**From:** Mark Norrell [REDACTED]  
**Sent:** 21 March 2019 11:18  
**To:** Charlotte Easton  
**Subject:** Re: 27 Pilgrims Way, Pagham - P/14/19/HH

I write to you regarding 27 Pilgrims Way, Pagham – reference P/14/19/HH.

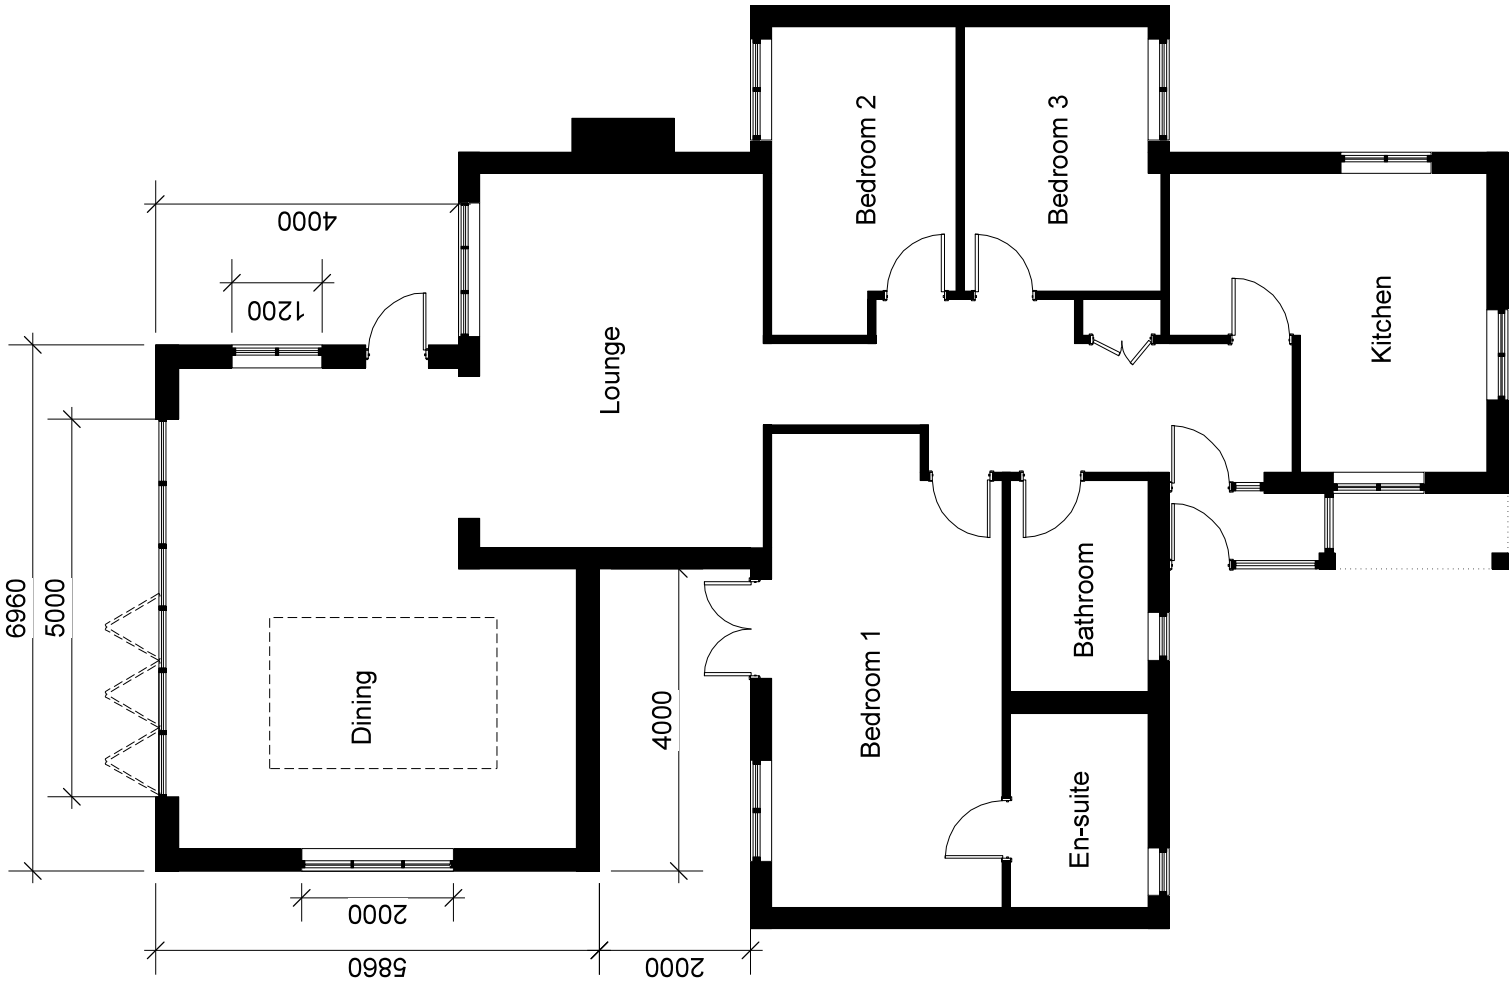
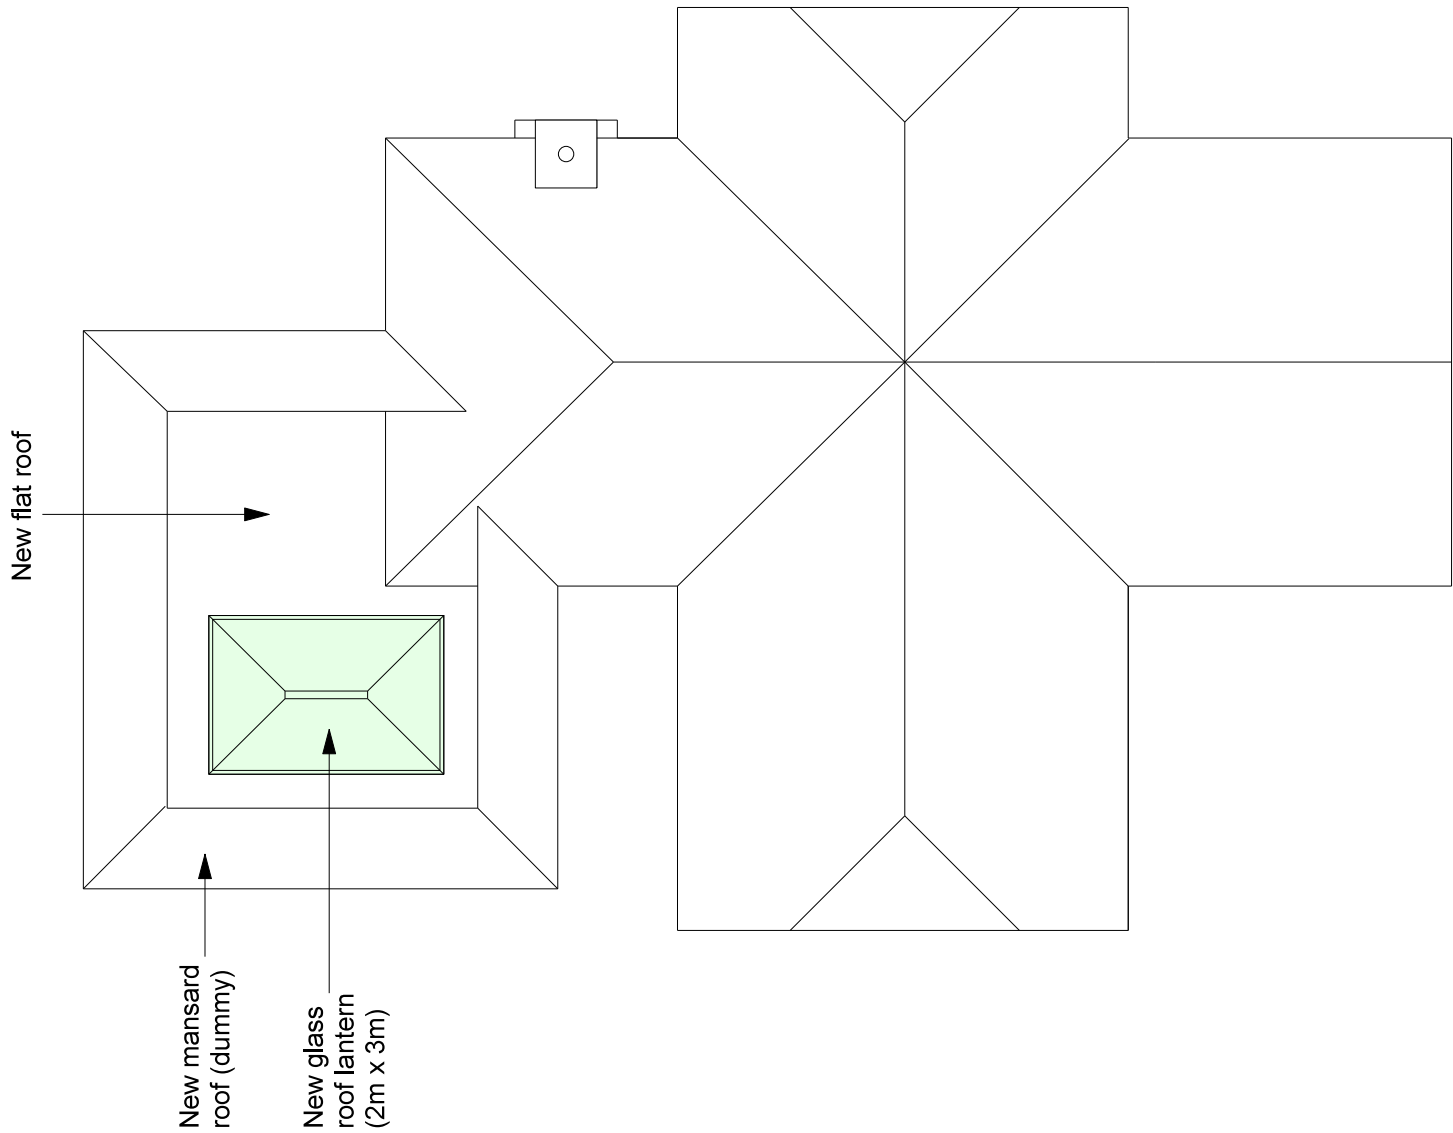
I am currently in the process of writing the report for this application and when doing so noticed that unfortunately the proposed ground floor plan (Dwg No. P004) submitted has incorrectly been labelled 'Existing ground floor plan'.

Therefore, could you please resend the proposed floor plan as amended to proposed.
